From: [Berry, Jon](#)
To: [Norfolk Boreas](#)
Subject: Norfolk Boreas Offshore Wind Farm Project Action Points
Date: 29 January 2020 10:16:27

I write on behalf of Breckland Council regarding the application by Norfolk Boreas Limited for an Order Granting Development Consent for the Norfolk Boreas Offshore Wind Farm Project. In particular this response is made in relation to Action Point 13 arising from Issue Specific Hearing 3 on the Onshore Effects, including the draft Development Consent Order, hearing held at Blackfriars Hall, St Andrew's Plain, Norwich, NR3 1AU on Tuesday 21st January 2020.

Action Point 13 requires Breckland Council to submit a response to the issues around the visual impact of the external equipment in Works 10A and comments on the proposed Secretary of State Norfolk Vanguard letter referenced REP3-012.

Outside electrical equipment required for the western extension to the existing Necton National Grid substation (Work No 10A) up to 15m

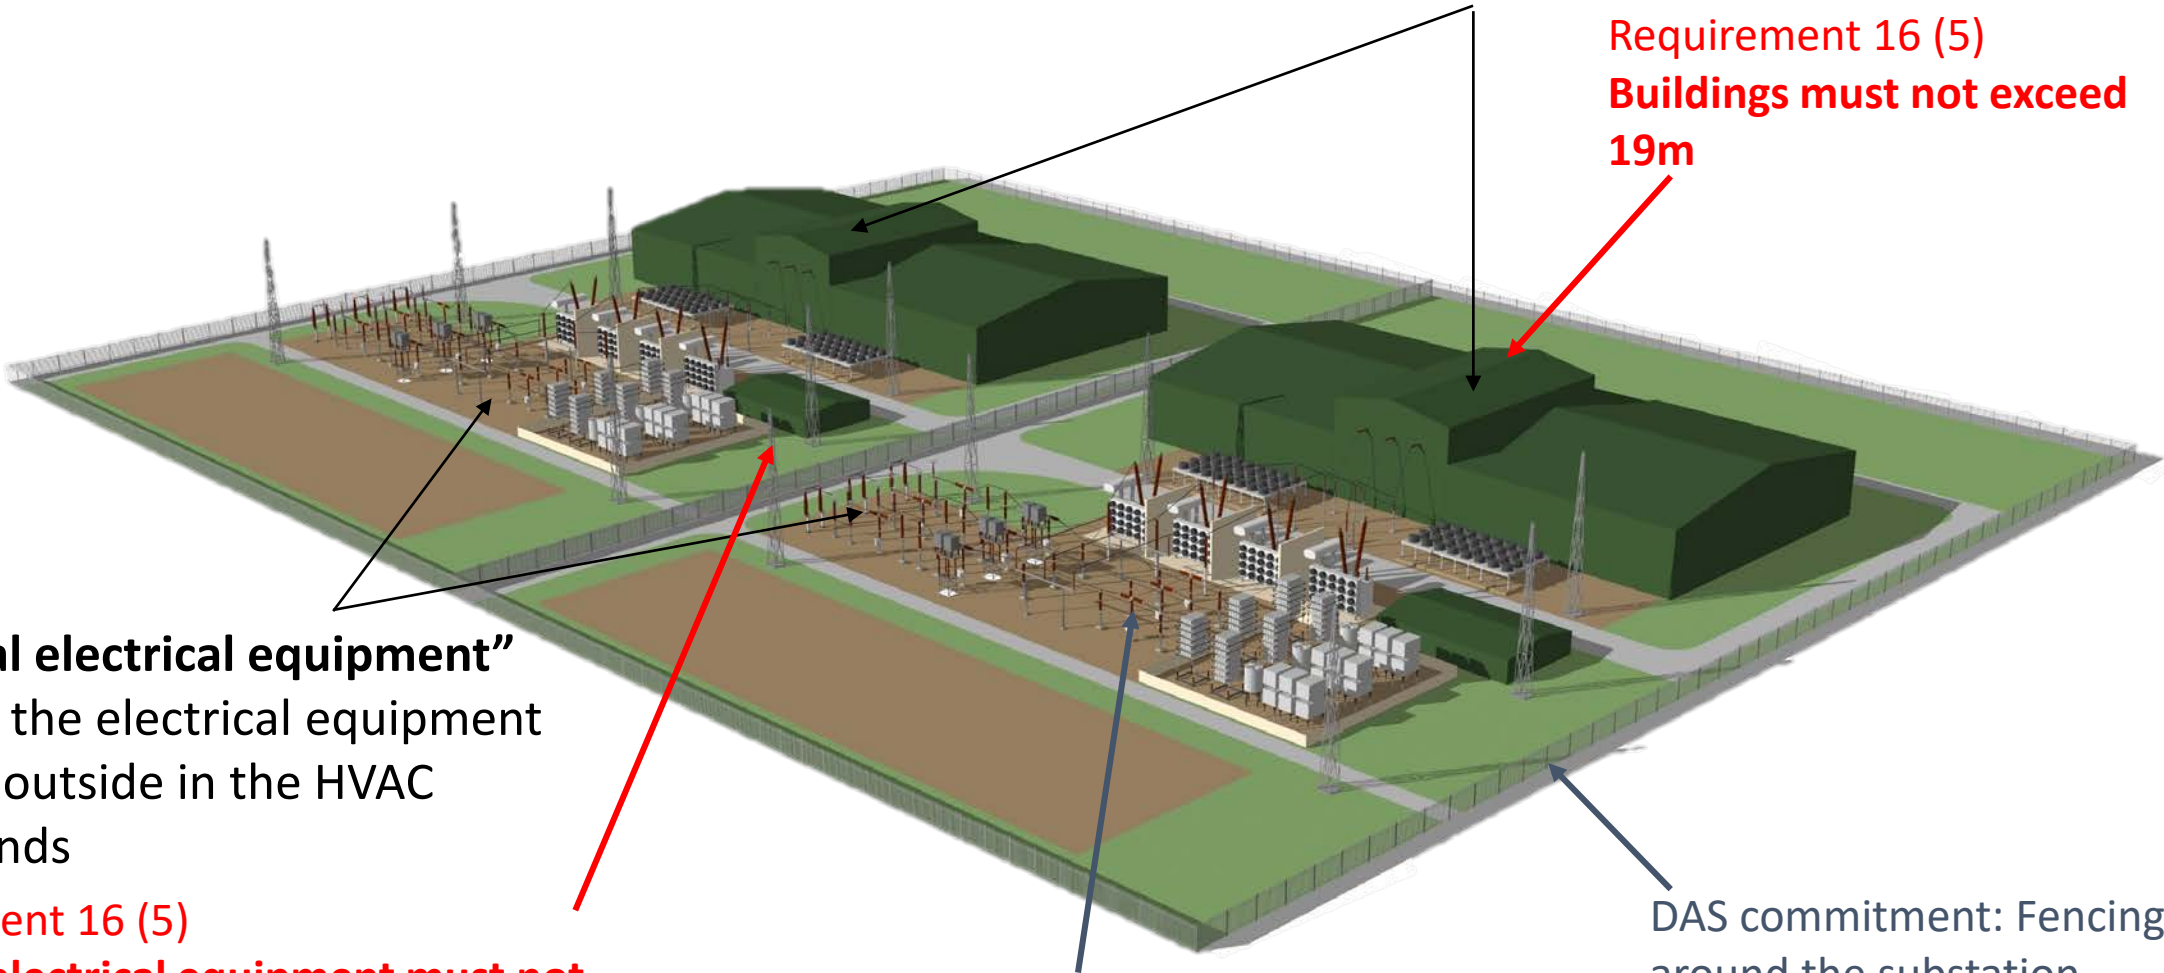
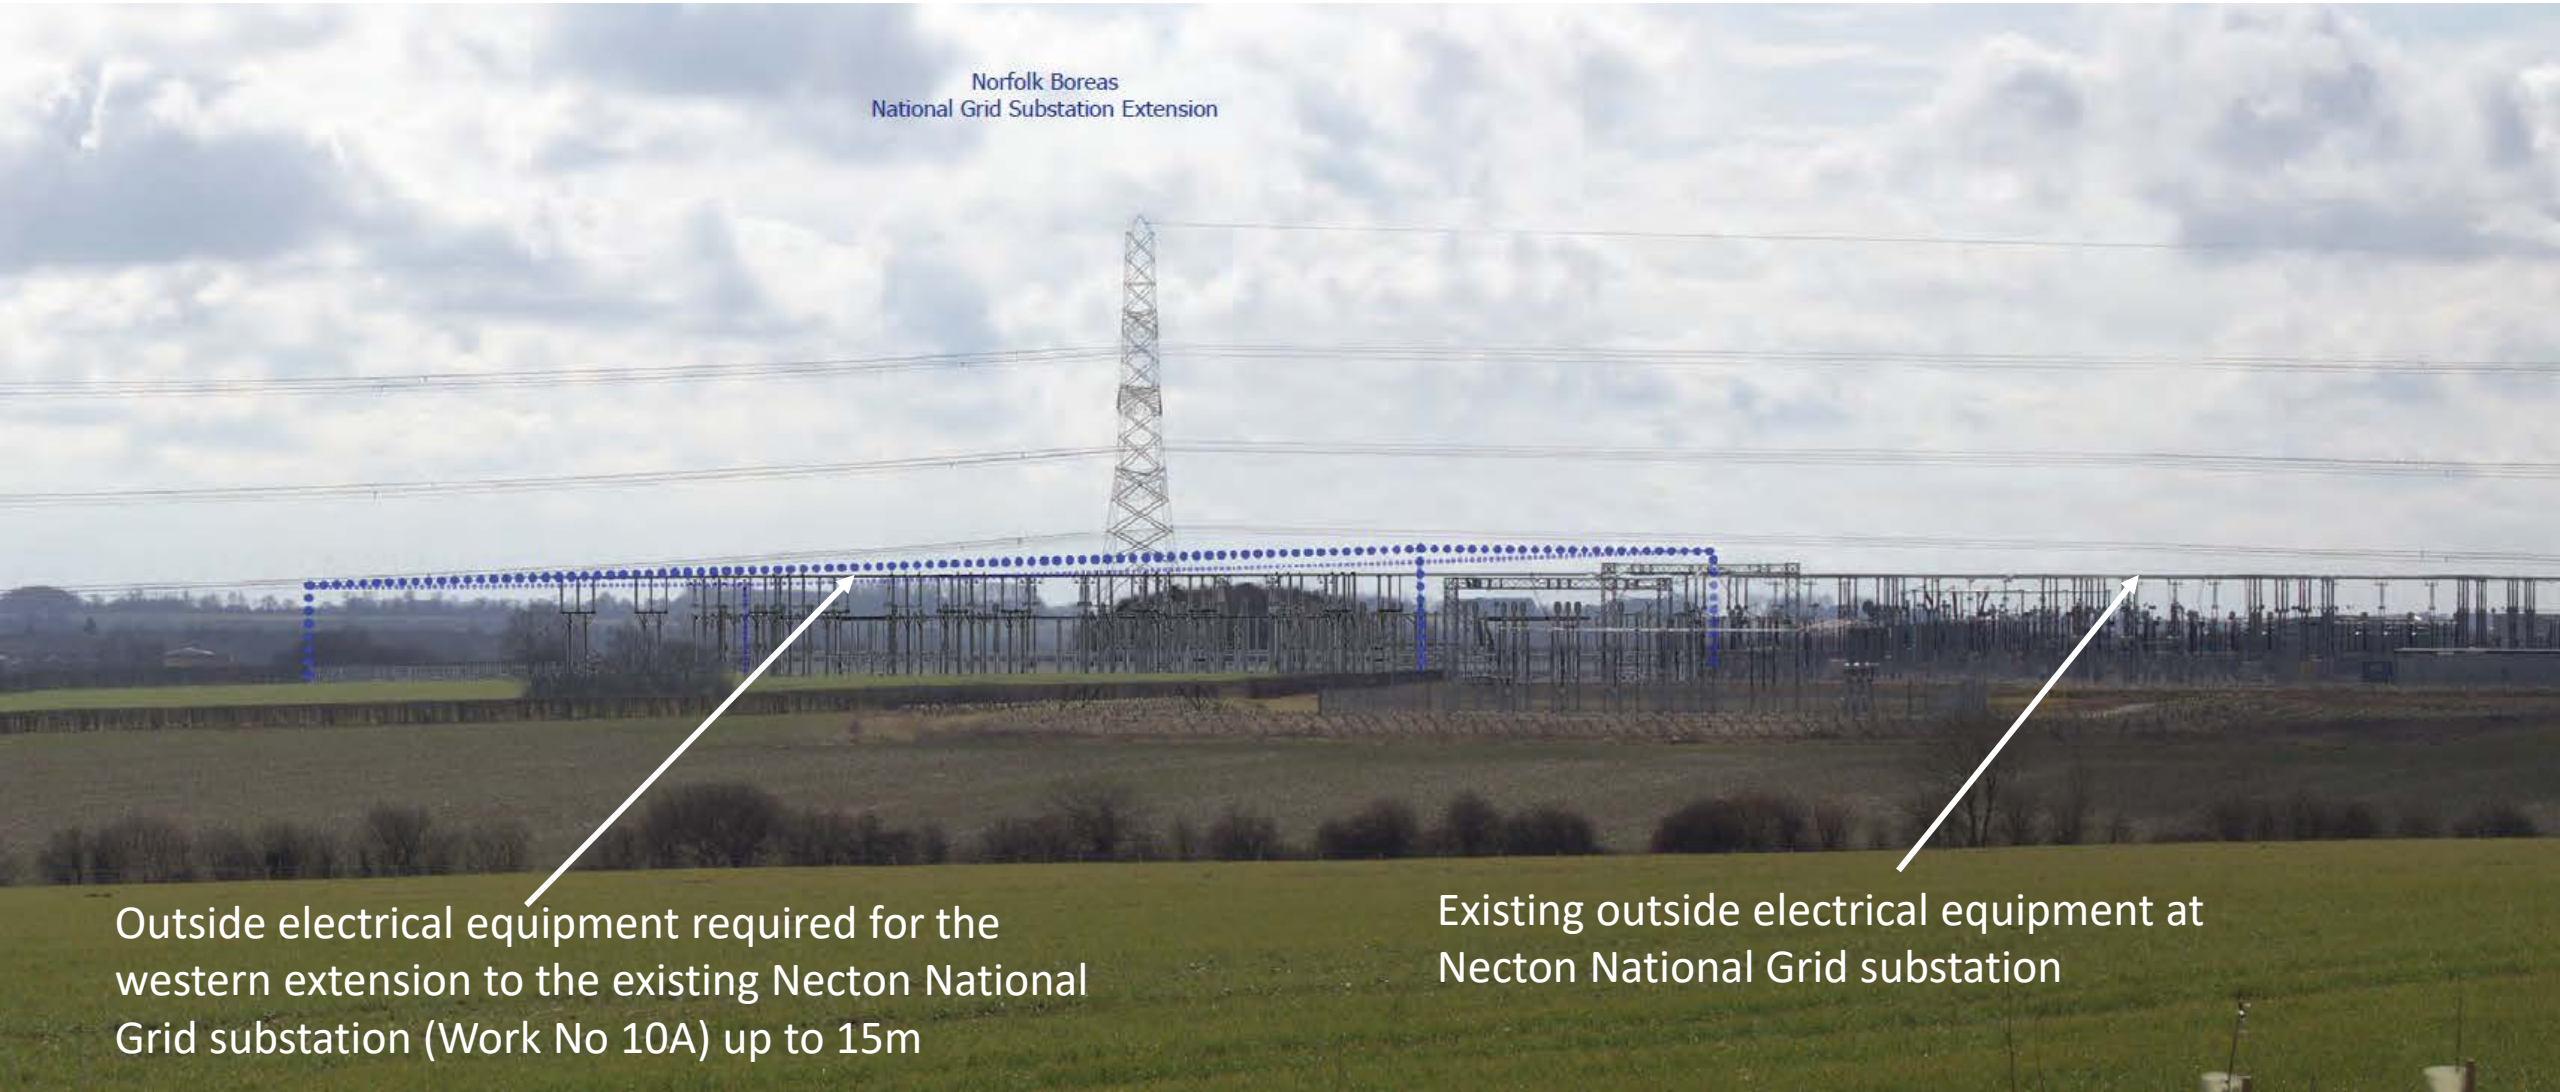
Breckland Council acknowledges the explanation provided by the Applicant that the necessary technical standards for the equipment associated with Works 10A mean there is little flexibility that can be achieved in terms of the design of this aspect of the development, which will be very similar to that of the equipment in the existing Necton National Grid substation. This will not be housed within a new building and will be visible from the external environment.

Therefore, as there is reduced scope for negotiation in terms of appearance, the Council would suggest a requirement that the equipment is powder-coated to minimise any light reflection and glare shining from the new aluminium and steel.
